COMMUNITY DEVELOPMENT DEPARTMENT
501 Delta Avenue ♦ Marysville, WA 98270 ♦ (360) 363-8000

February 13, 2024

Re: Harborview Heights – Technical Review 1
SP23-007

After reviewing the application materials for the above referenced proposal, the following technical review comments are provided:

HARBOR VIEW HEIGHTS SHORT PLAT

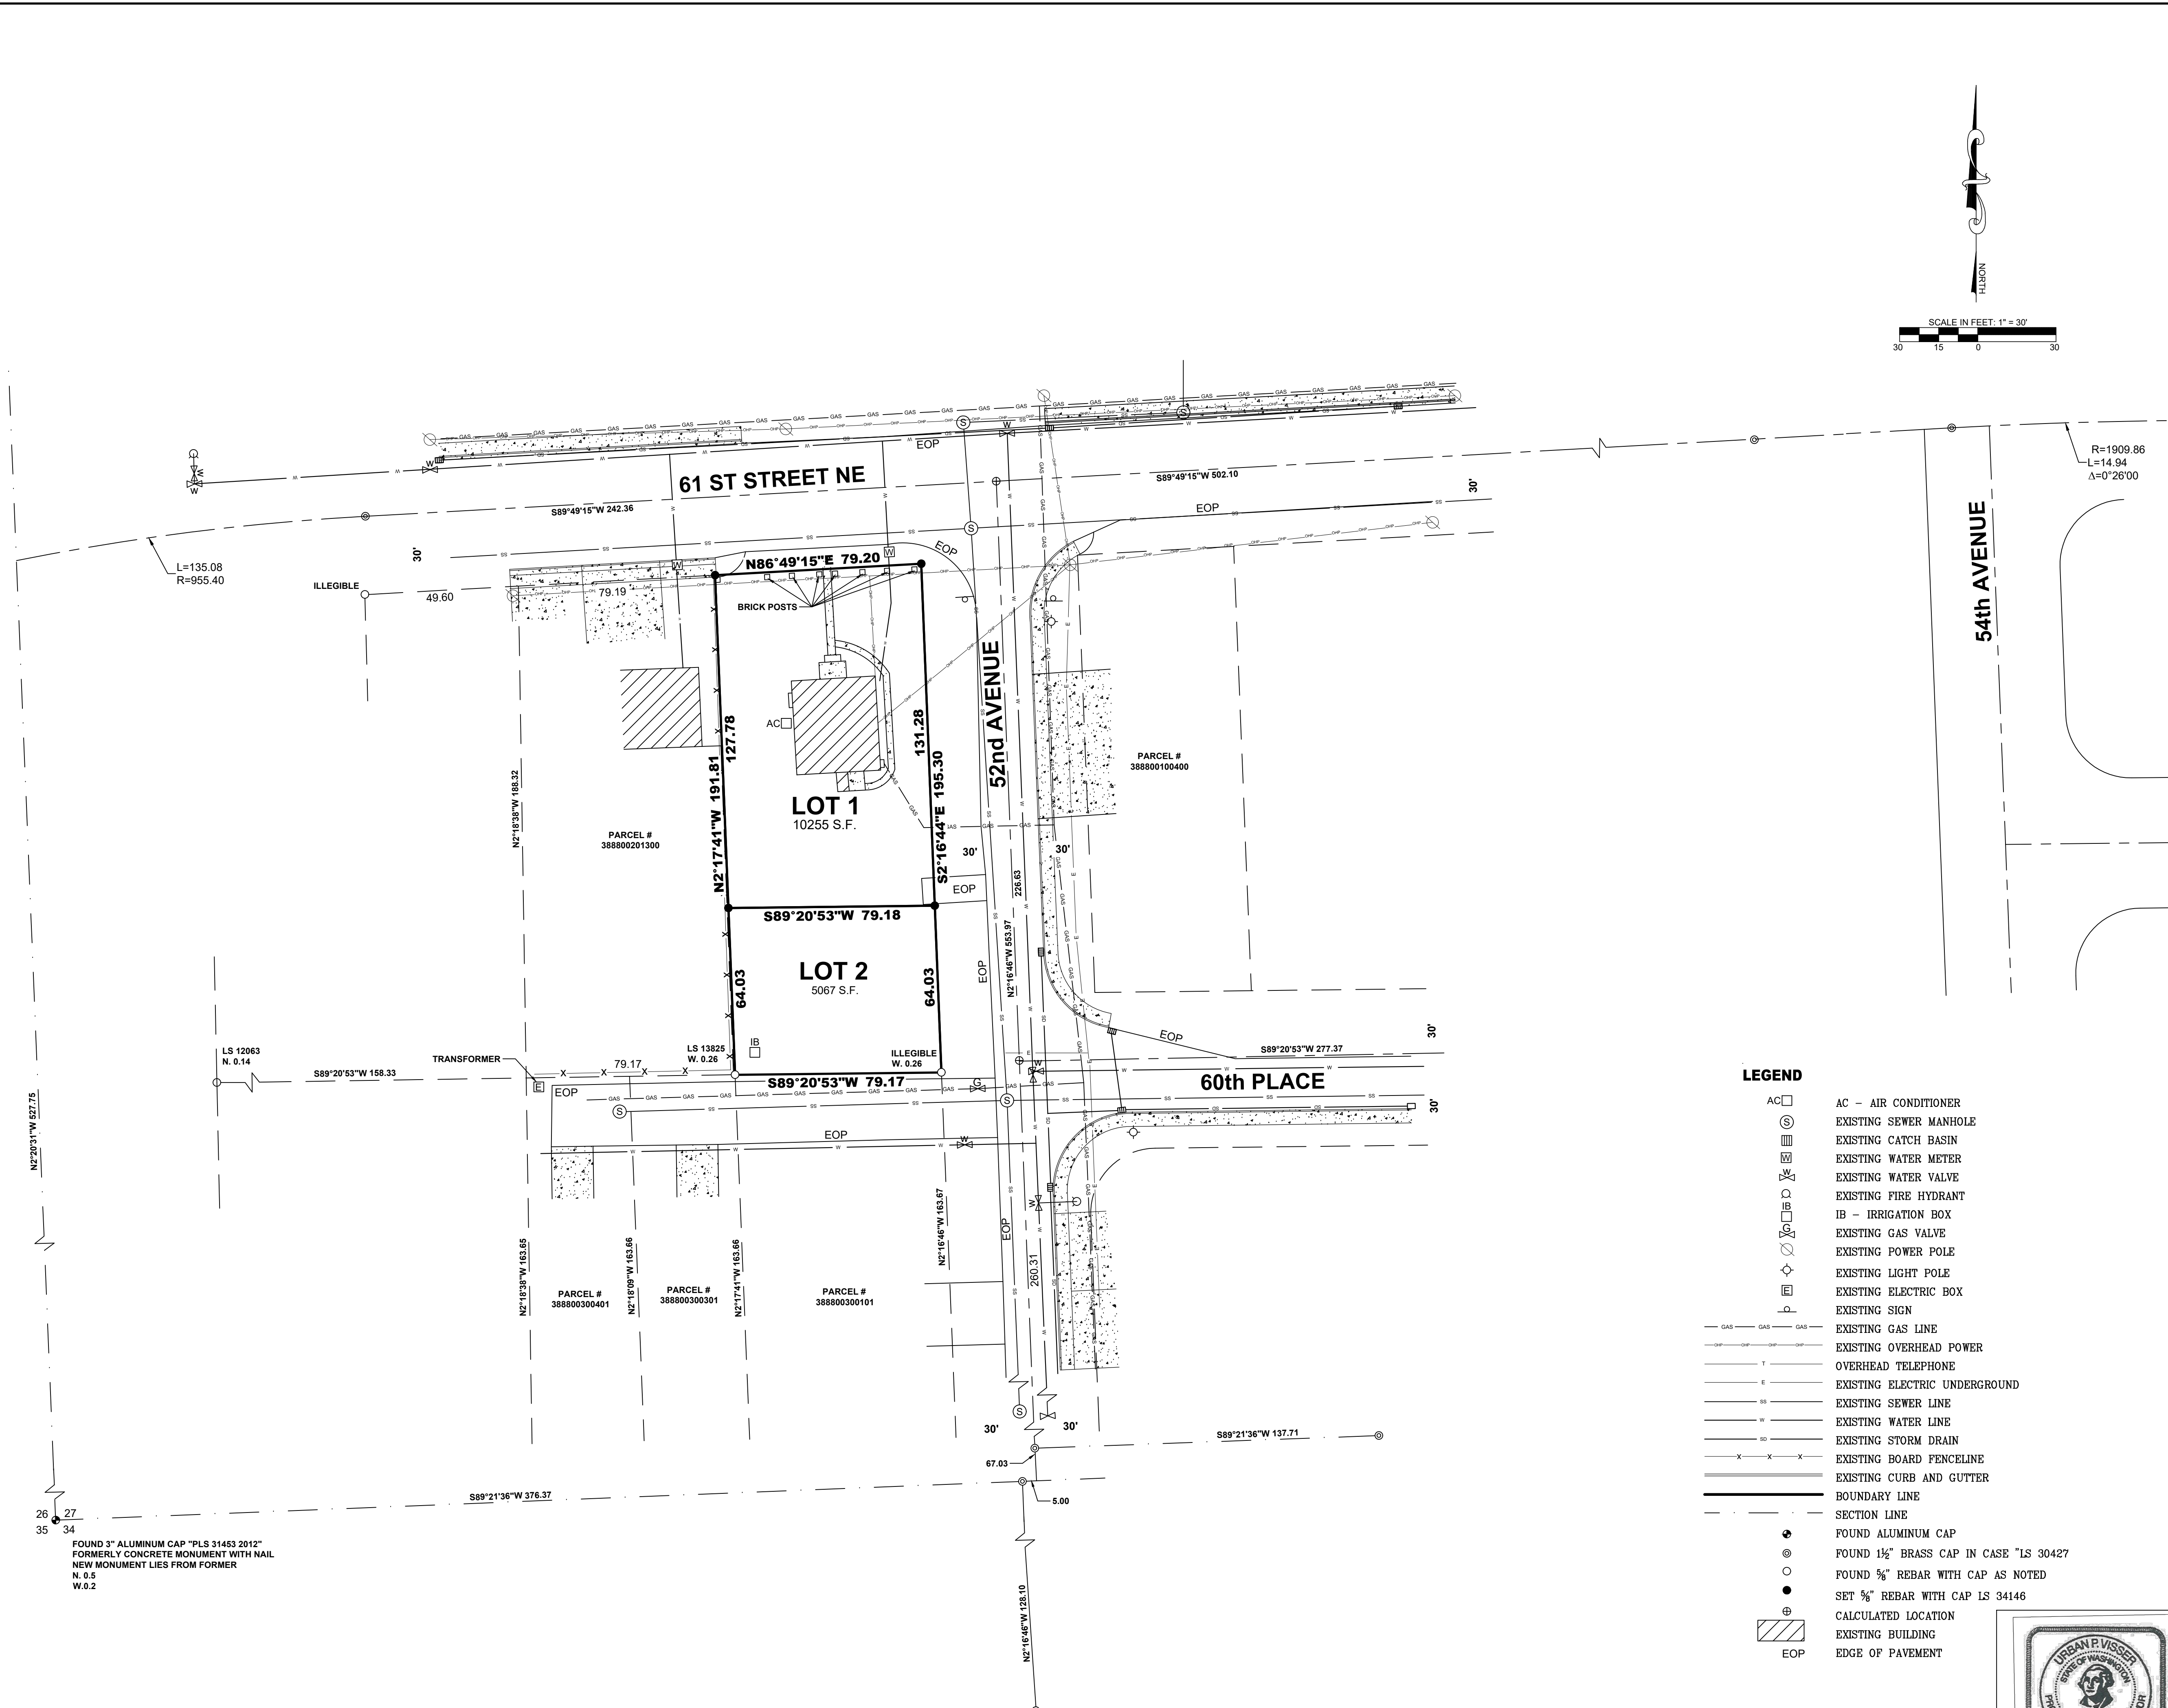
1. Please include file number SP23-007 on all future maps.
2. Show the following setback lines on the preliminary short plat map:
 - a. Lot 1:
 - i. Front yard 20ft
 - ii. Rear yard 20ft
 - iii. Side yard (52nd Ave) 10ft
 - iv. Side yard (west) 5ft
 - b. Lot 2:
 - i. Front yard 20ft
 - ii. Rear yard 20ft
 - iii. Side yards 5ft

3. Amend the preliminary short plat map, to include the following table:

Zone R-6.5 Densities and Dimension Standards (MMC 22C.010.080)	
Maximum Density	6.5 du/acre
Min. Street Setback	20 feet
Min. Side Yard Setback	5 feet
Min Side Yard Set Back Lot 1 (52 nd)	10 feet
Min. Rear Yard Setback	20 feet

4. Amend the preliminary short plat map to include the following:
 - a. Net project area calculations (see definition in [MMC 22A.020.150](#))
 - b. Building Coverage calculations for lot 1

- c. Impervious surface calculations for lot 1 (see definition in [MMC 22A.020.100](#))
5. All proposed fences shall comply with [MMC 22C.010.380](#)
6. The applicant shall be required to submit a preliminary landscaping plan that includes the following:

7. Pursuant to MMC 22C.130.030 table 1, a minimum of 3 parking stall are required for each lot. The short plat map will be required to be amended to demonstrate compliance for lot 1. All parking stall are required to be a minimum of 8.5 ft. wide and 18 ft. deep. Additionally, off street parking stalls shall be required to be surfaced with an all-weather surface approved by the city engineer. Gravel is not considered an all-weather surface.

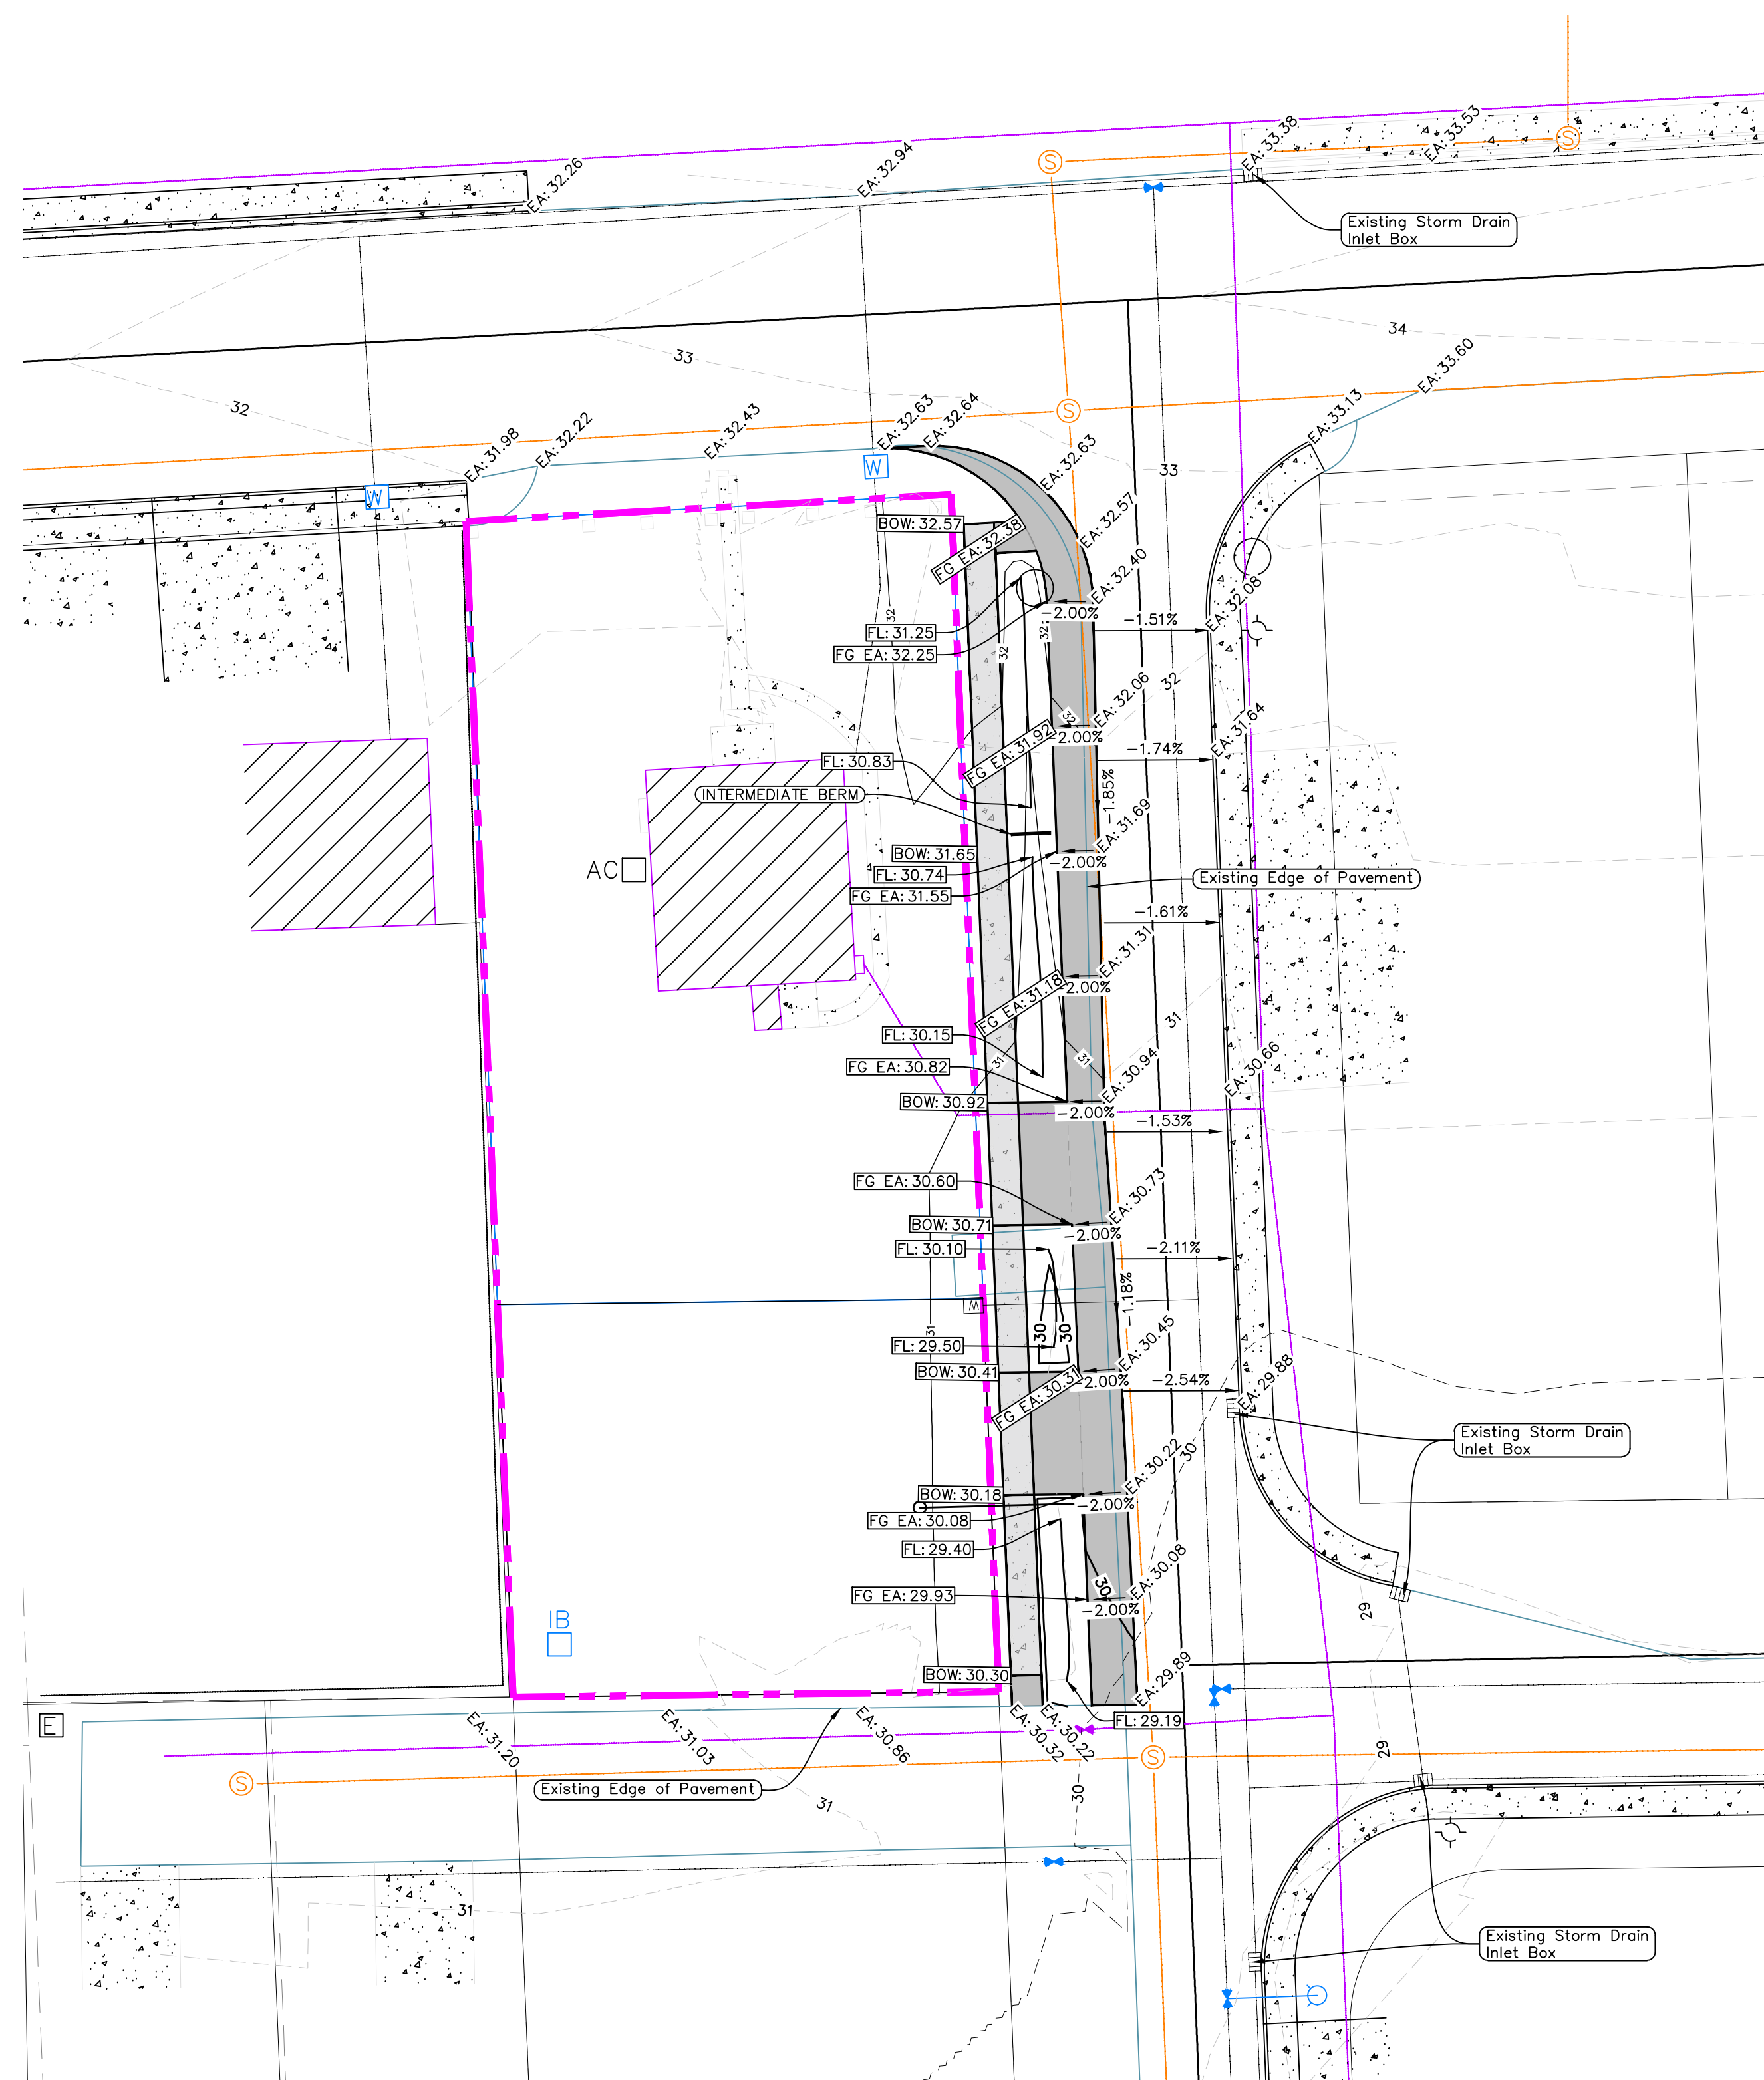
8. Amend sheet SP-01 to depict existing side sewer service to the existing house on lot 1.
9. All subdivisions or short subdivisions shall have all necessary power lines, telephone wires, television cables, fire alarm systems and other communication wires, cables or lines placed in underground location either by direct burial or by means of conduit or ducts and, with the exception of the city fire alarm system, providing service to each lot or potential building site in the plat. This include the existing overhead utilities for lot 1.

23. The plans show an 8 foot wide biocell. Maximum width allowed within the right-of-way would be 5 feet. Typically the biocells do not align with the required landscaping within the right-of-way, recommend moving the cells behind the sidewalk.
